**MIKE CAUSEY**  
INSURANCE COMMISSIONER & STATE FIRE MARSHAL

February 4, 2021

**RE: GOOD HOPE HOSPITAL  
New Building Expansion – Mental Health  
Harnett County**

Plans relative to the above referenced project have been reviewed for general compliance with the 2018 North Carolina State Building Code with the following comments:

CONTRACT NAME:	GOOD HOPE HOSPITAL
CONTRACT WITH:	STE GENERAL CONTRACTORS
DESCRIPTION:	INFORMATION
SYSTEM DESIGN DATA	
CONTRACT NO.:	20K533
DRAWN BY:	M.FORD
DRAWING NO.:	FP 1 of 3

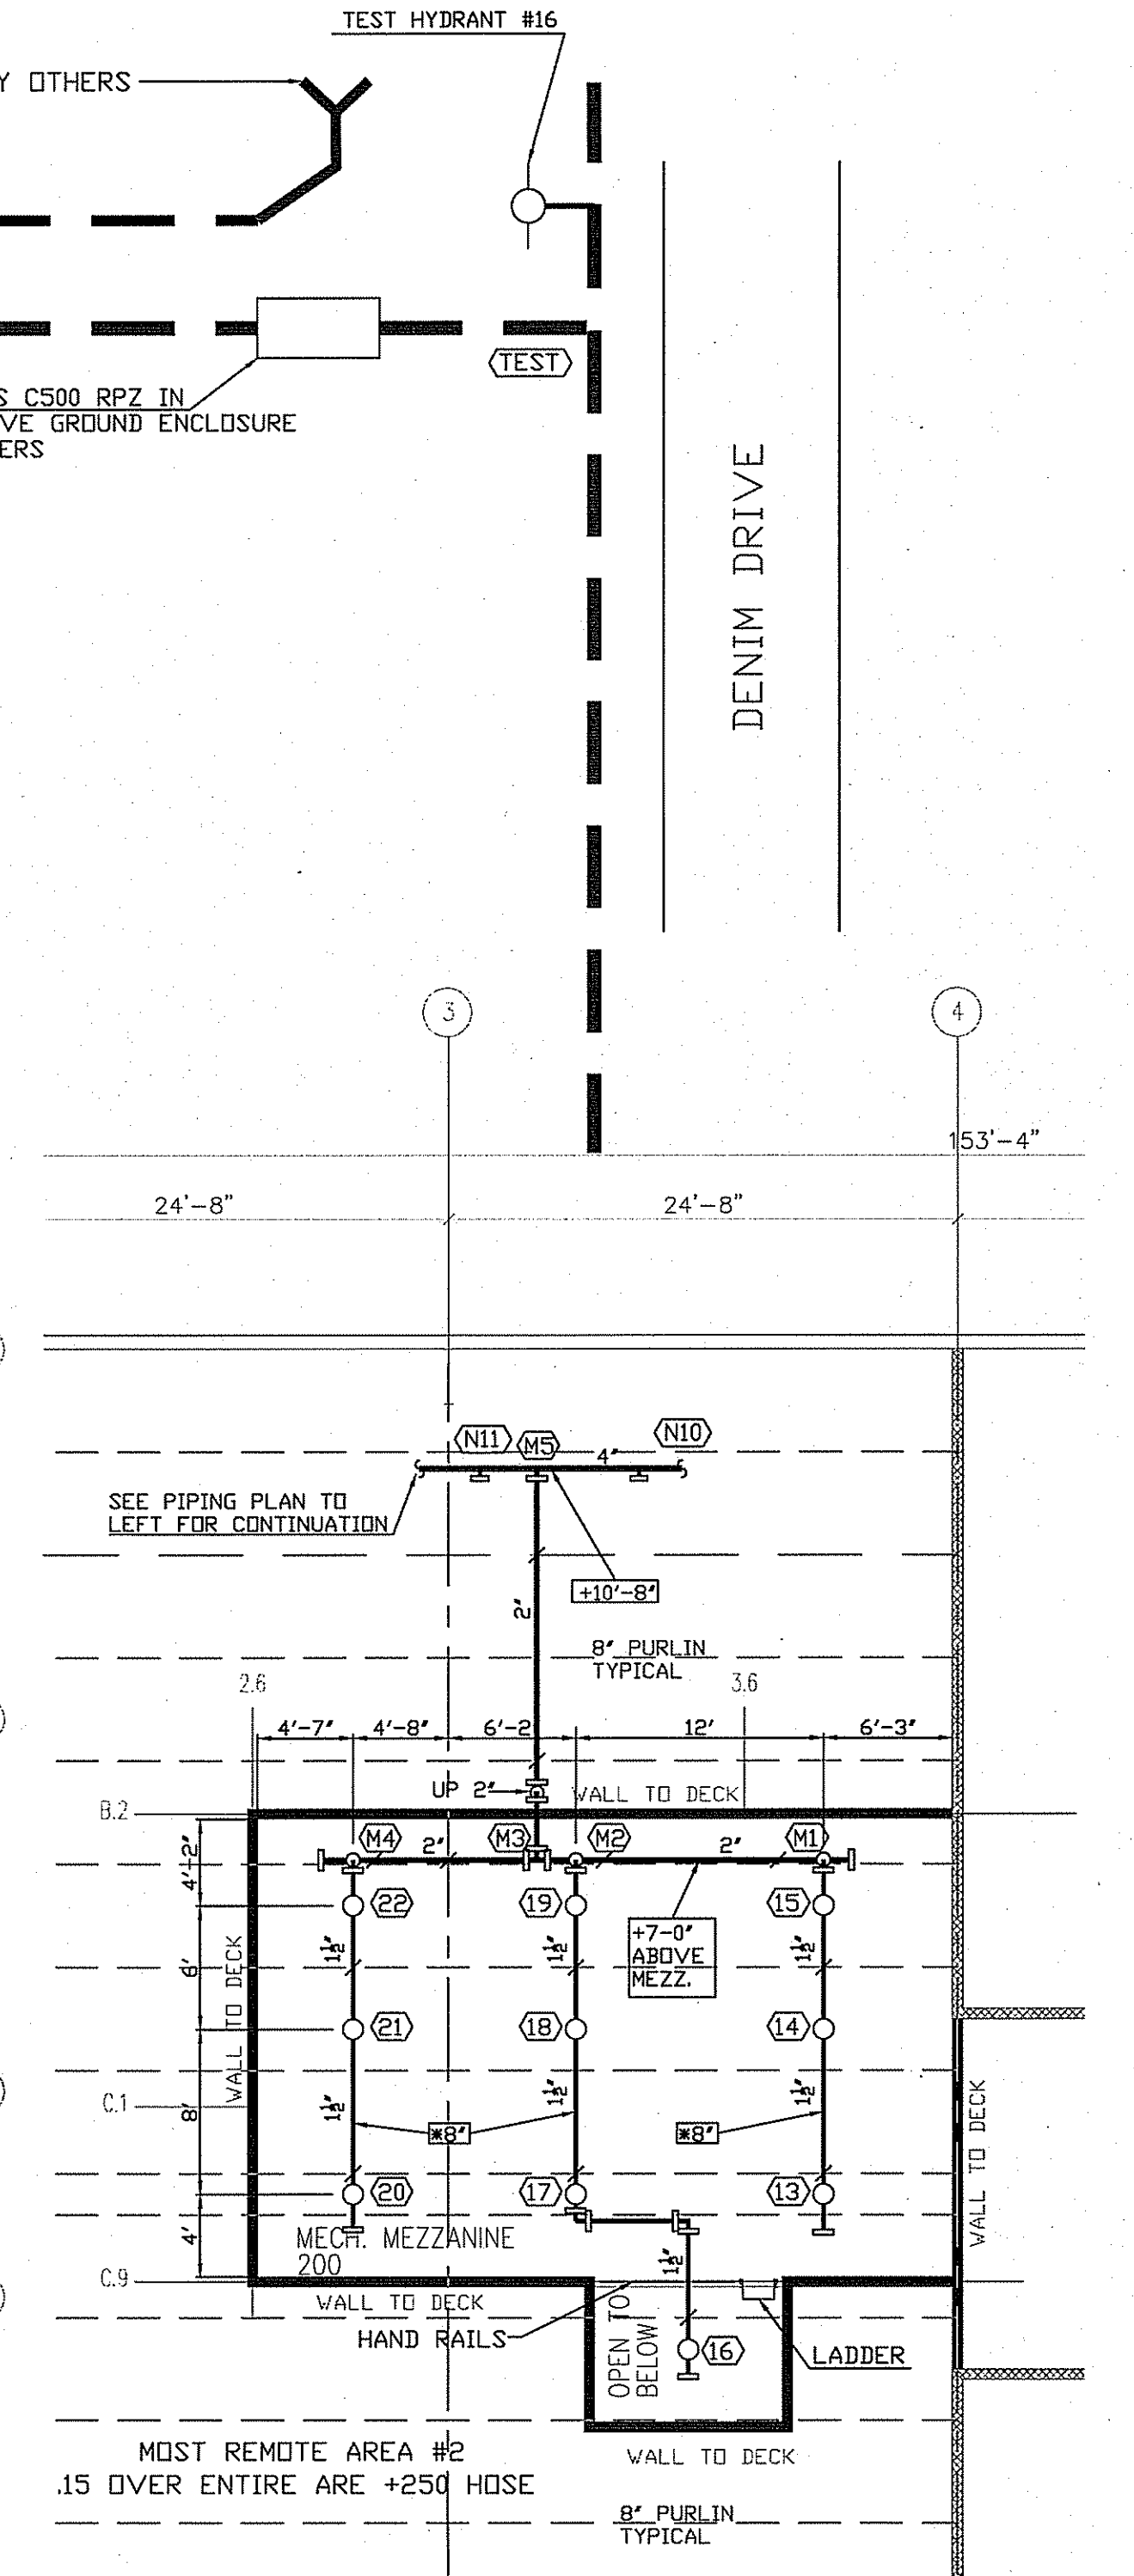
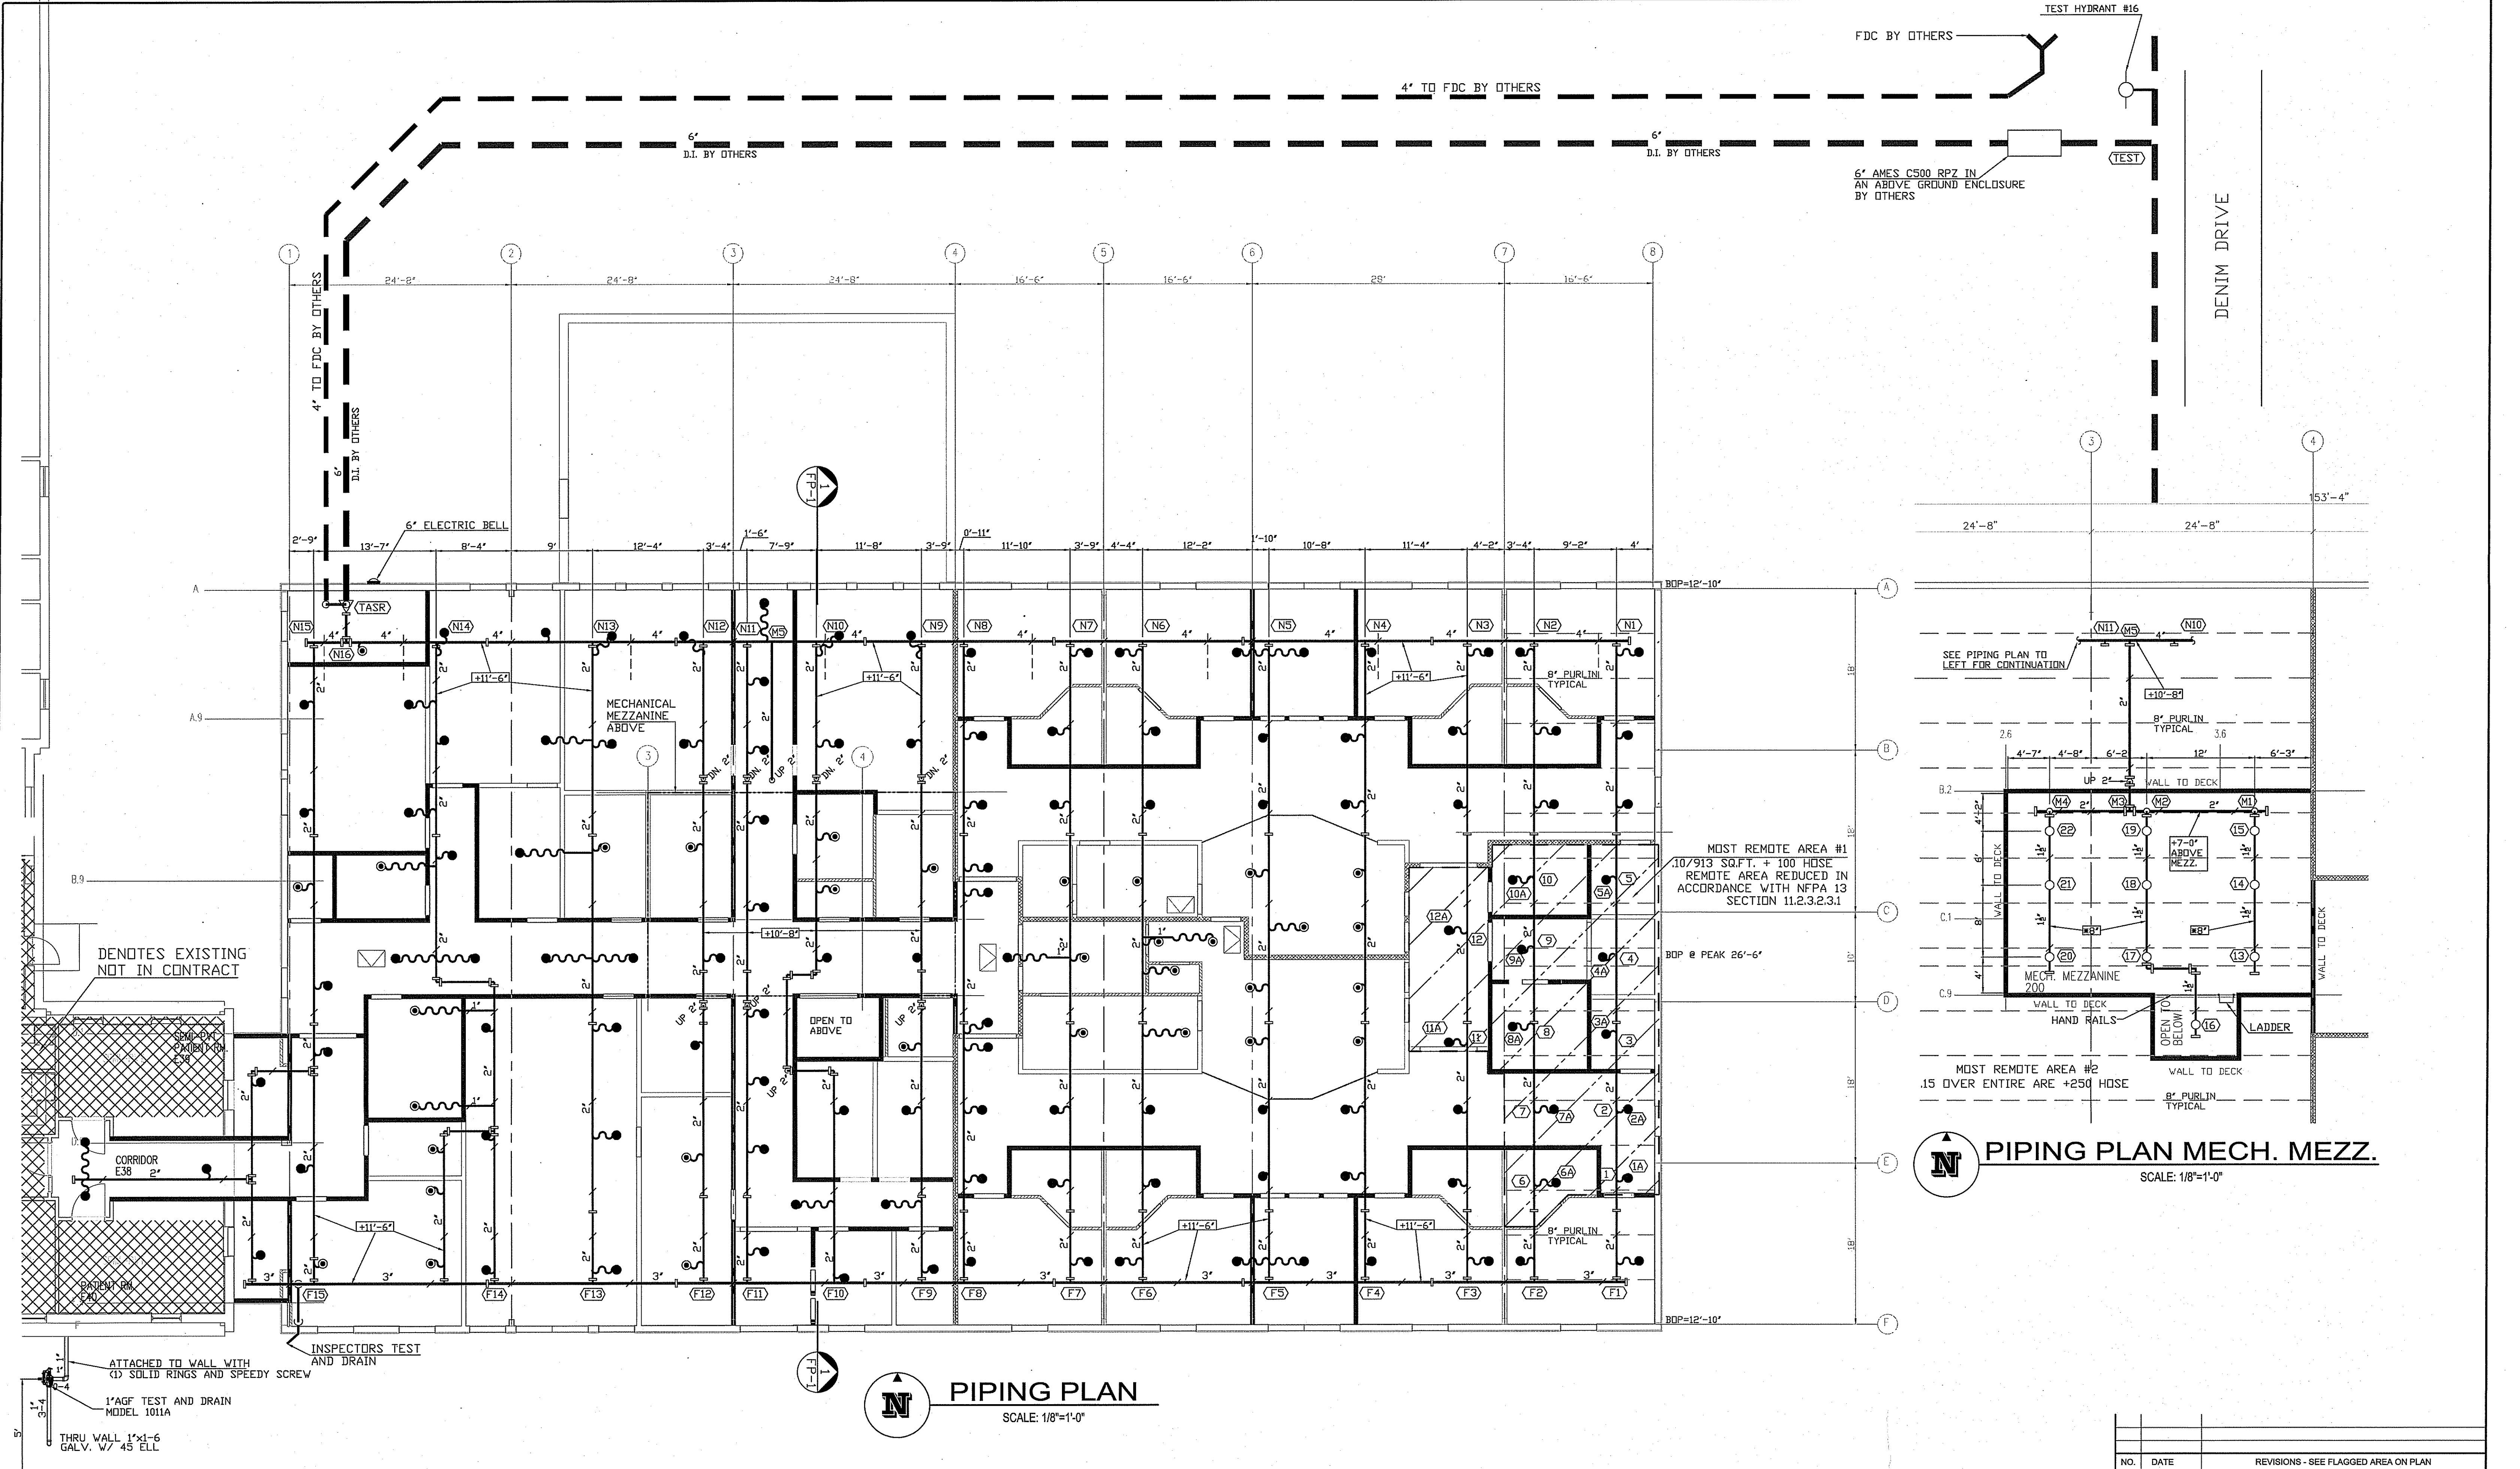
4. Verify and clarify automatic sprinkler system is also installed in the concealed spaces (Mechanical Mezzanine) in accordance with Section 903.2.11.1 in both new addition and existing building. [2018 North Carolina Building Code Section 717.1 and 717.5]
